Our Ref: BR/106/17/HH
Your Ref:

Town & Country Planning Act 1990 (as amended)
Town & country Planning (Development Management Procedure) (England) Order 2015
Application for Planning Permission for Works or Extension to a Dwelling

Development Rear extension
Location 125 Orchard Way Bognor Regis

SITE LOCATION & BLOCK PLANS			
Scale	1:1250 - 1:500	Drawn By	ACB
Date	01/11/2016	Checked	CB
Drawing Number	1360 - 01A

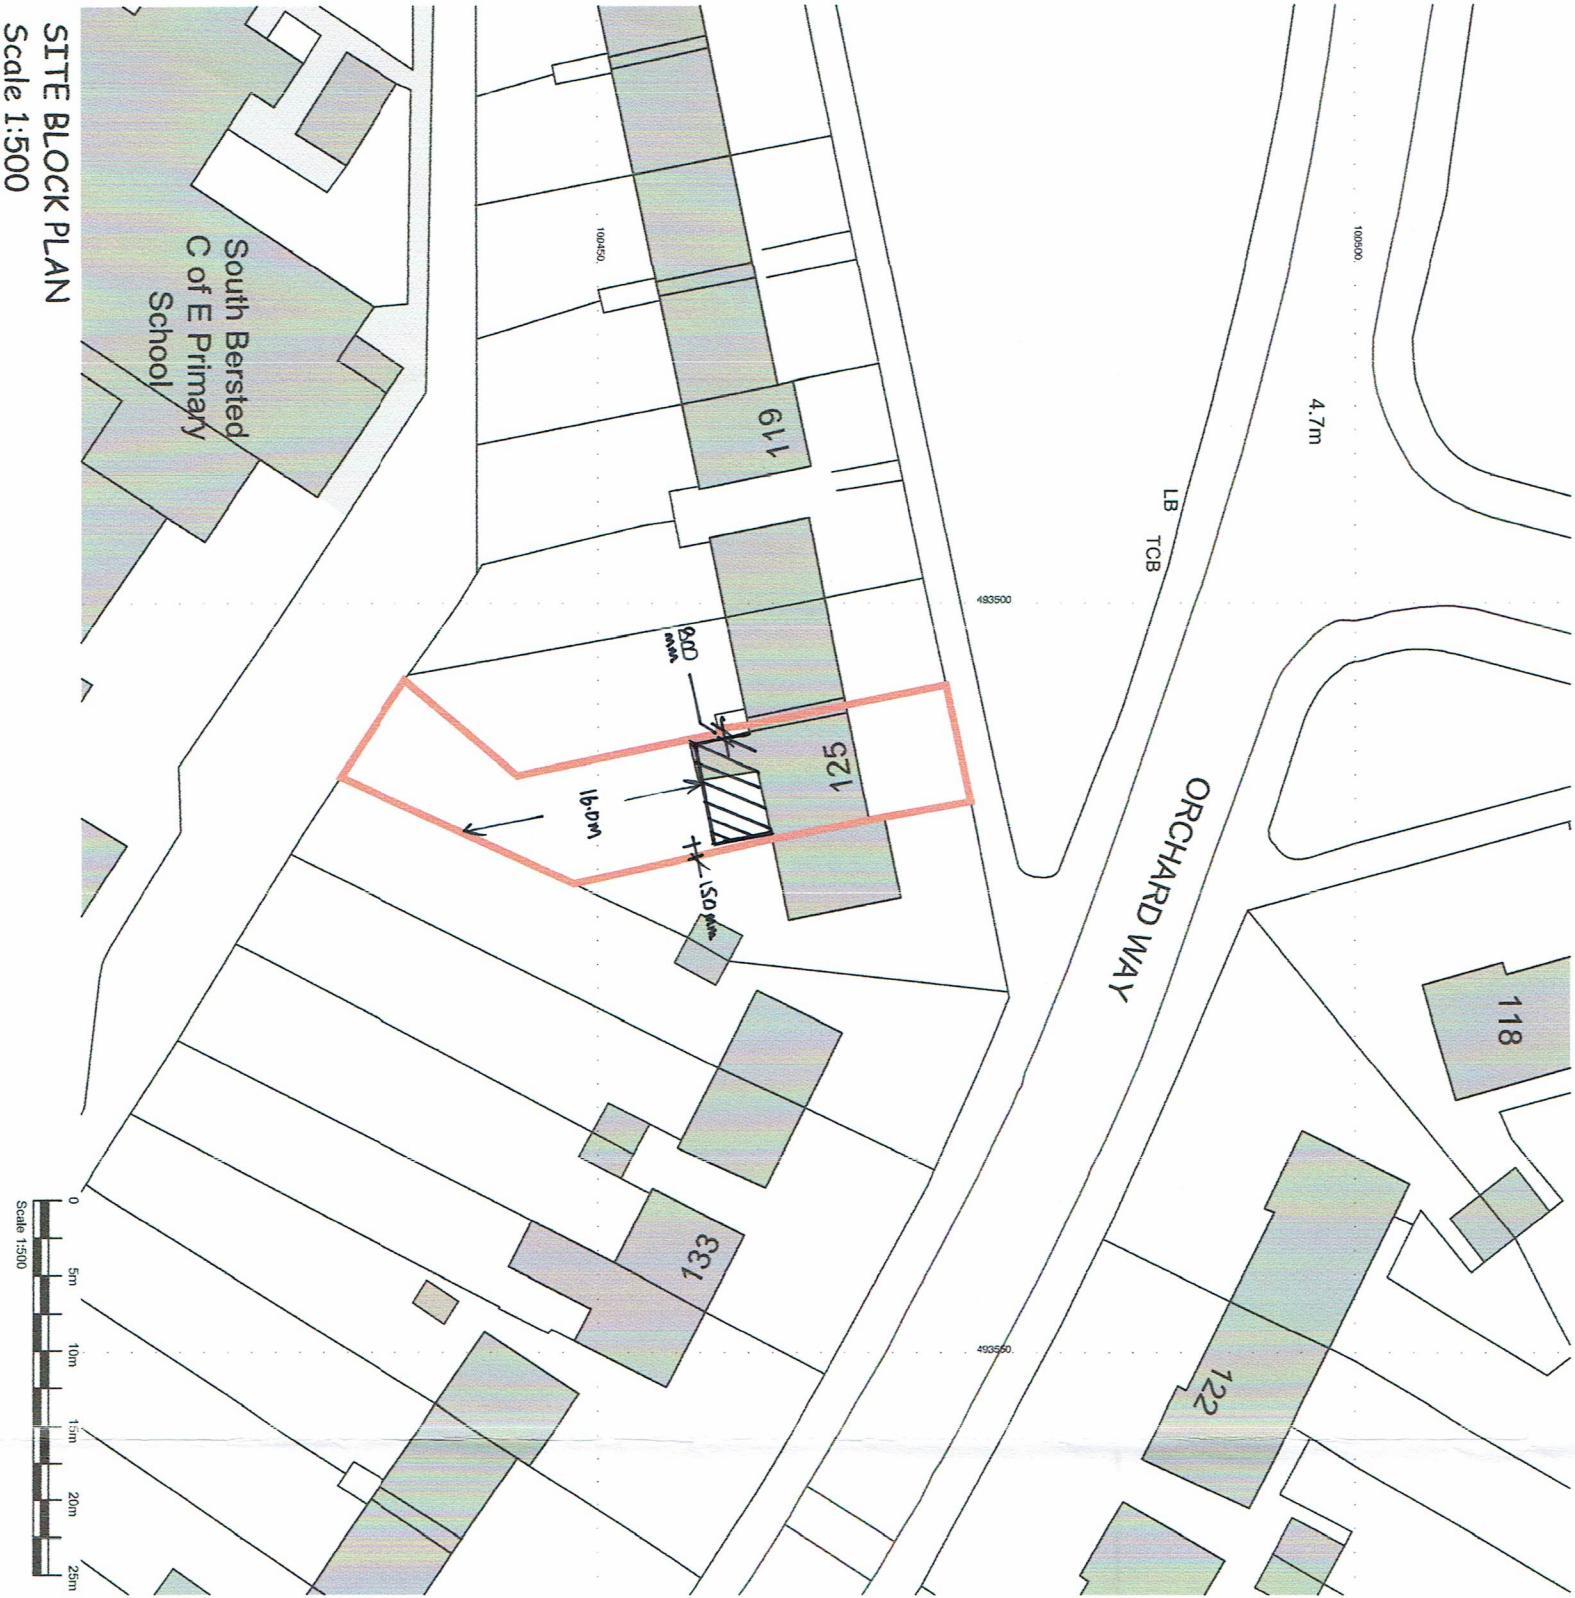
Block Plan Amend

Please submit 1 electronic or 3 paper copies of a block/site plan at a scale of 1:500 or 1:200. Further details of what must be included on the plan can be found in the National Validation Requirements. Please highlight/hatch the proposed works and provide measurements from the proposal to the site boundaries.
